**Consultation Response from KC,
Lead Local Flood Authority**

2024/91199 140A, Manchester Road, Longroyd Bridge, Huddersfield, HD1 3JA

Demolition of existing building and erection of student accommodation with ancillary spaces, associated garden area, store and landscaping, access and car parking

Date Responded: 12/06/2024.

SITE PLAN Scale 1:100 0 5m 10m

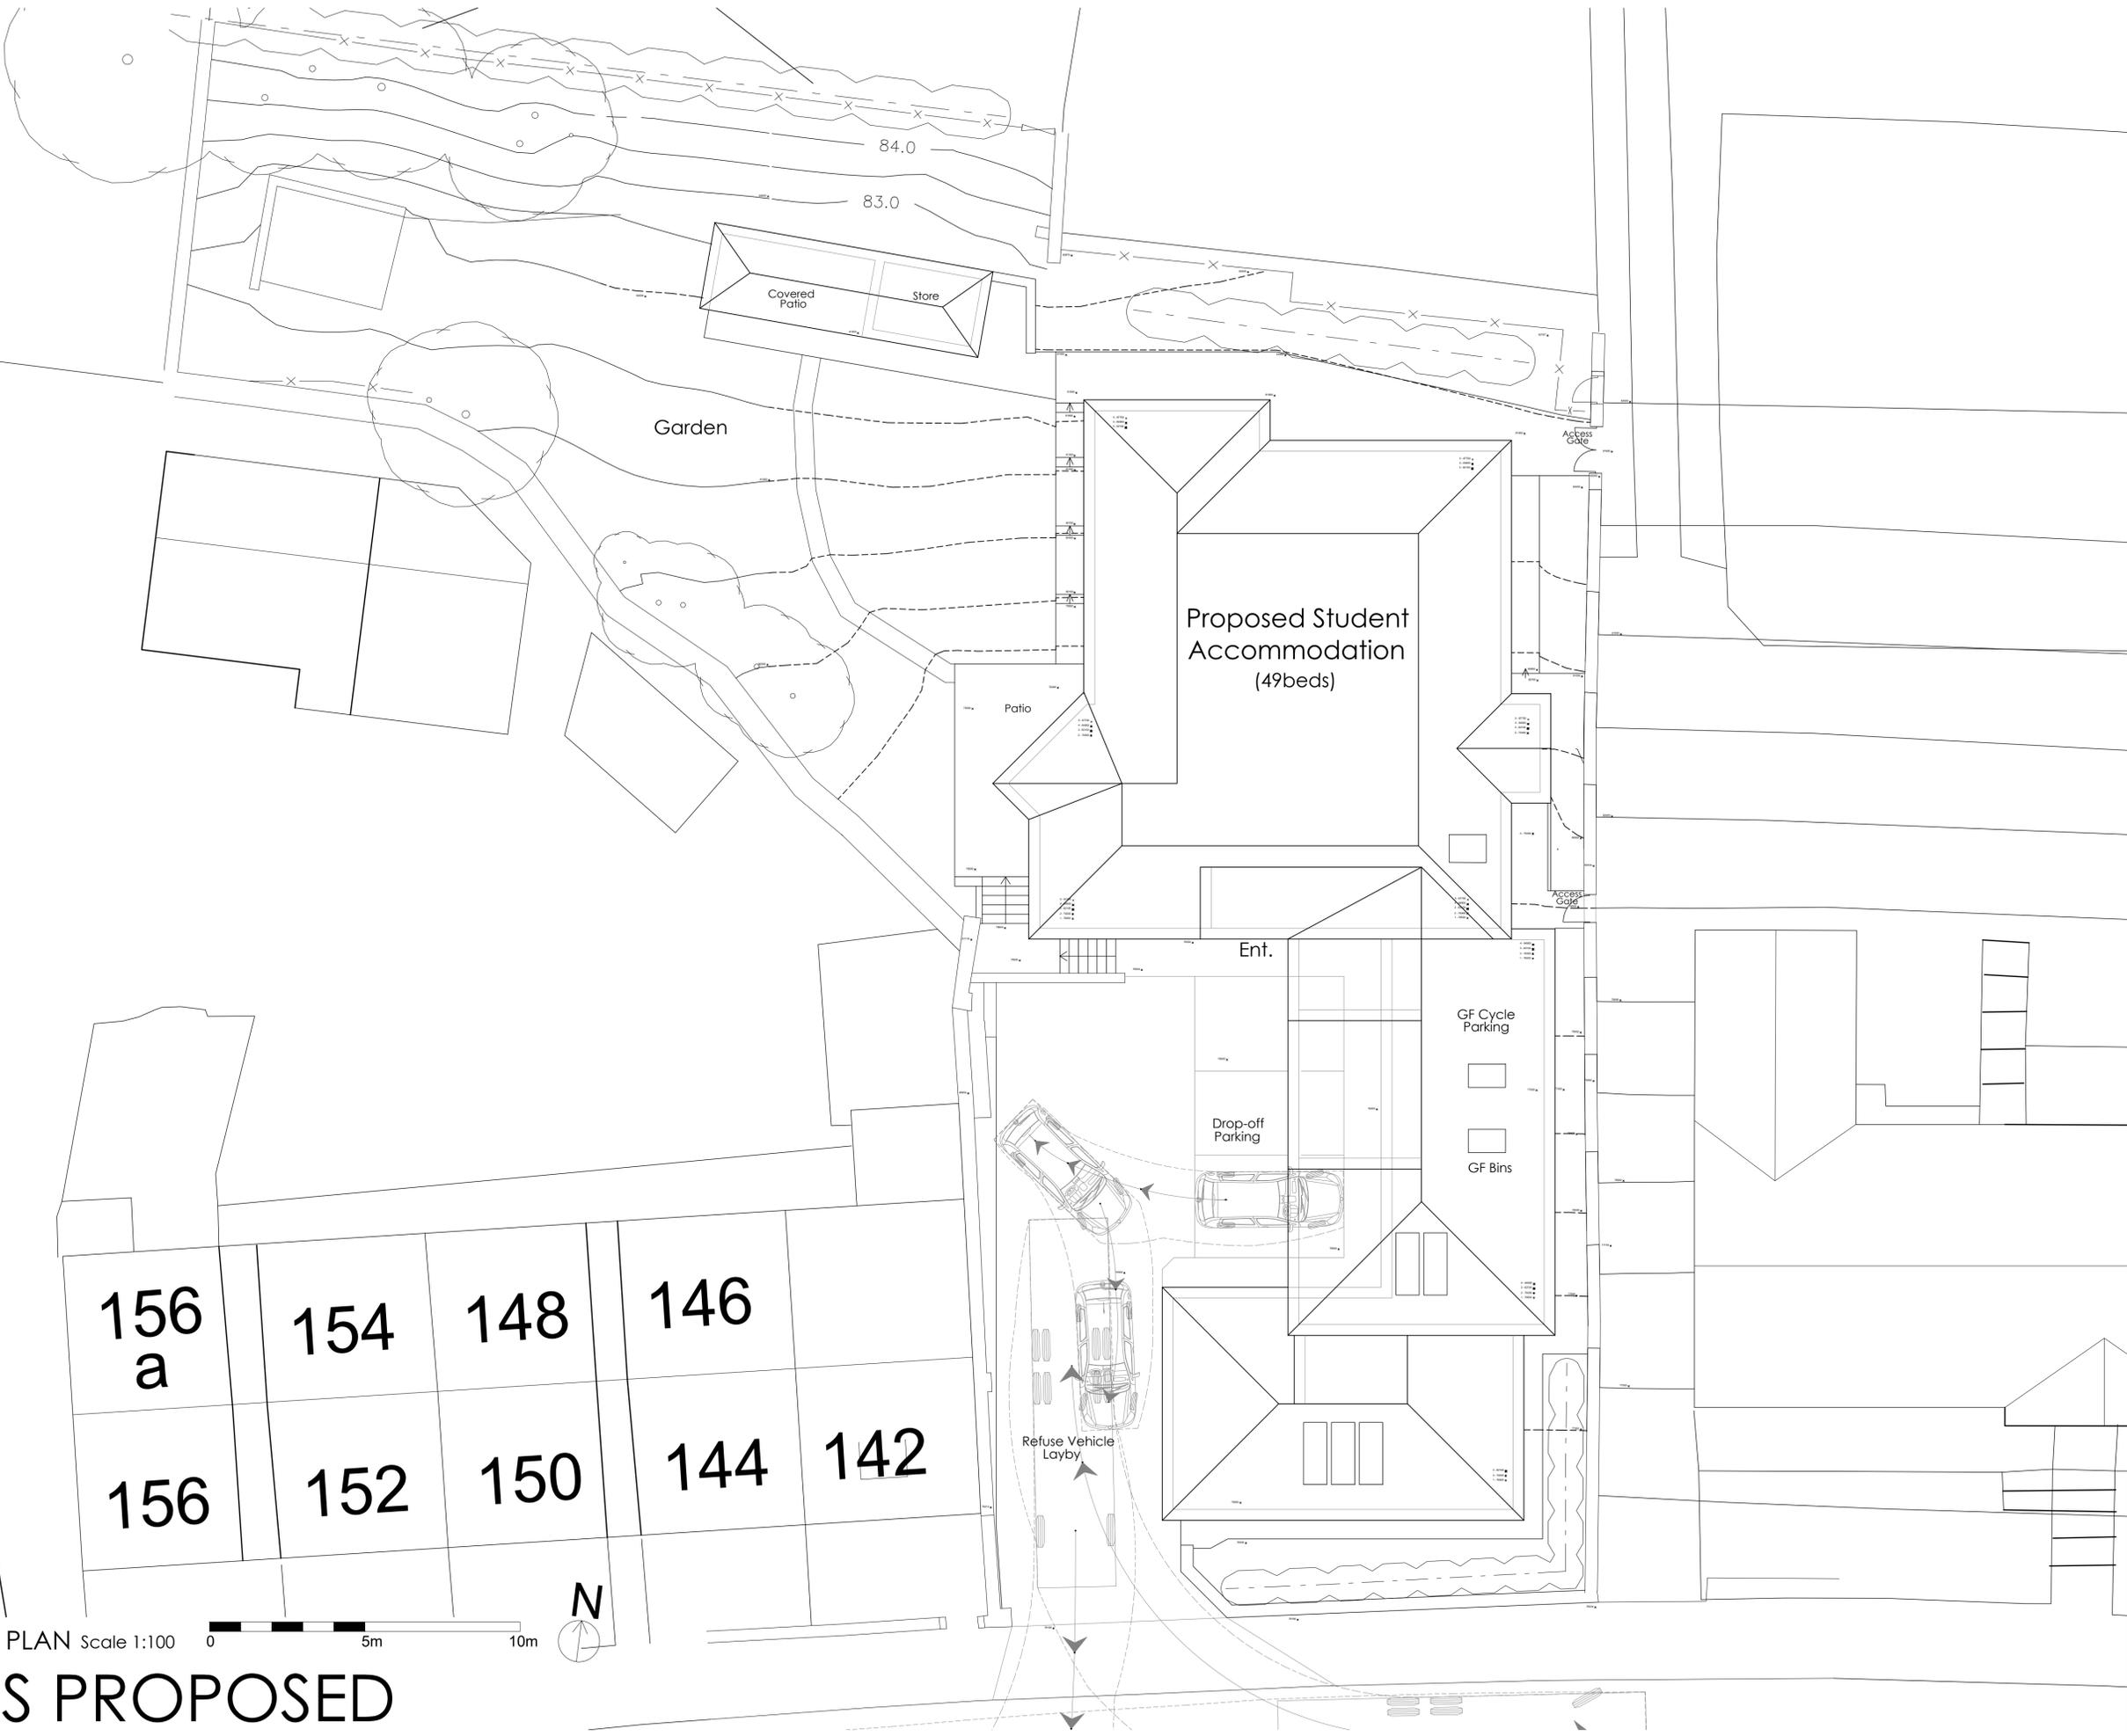
The LLFA confirms that the proposed allowable surface water discharge rate of 3.5 l/s via an 82mm dia HydroBrake to the Yorkshire Water Combined Sewer in Manchester Road is acceptable. It is assumed that the HydroBrake will be located in the final SW MH (S1 on the Drainage Plan).

The LLFA also confirm that the proposed attenuation storage of 16m³ in an oversized pipe as shown in the hydraulic calculations is acceptable.
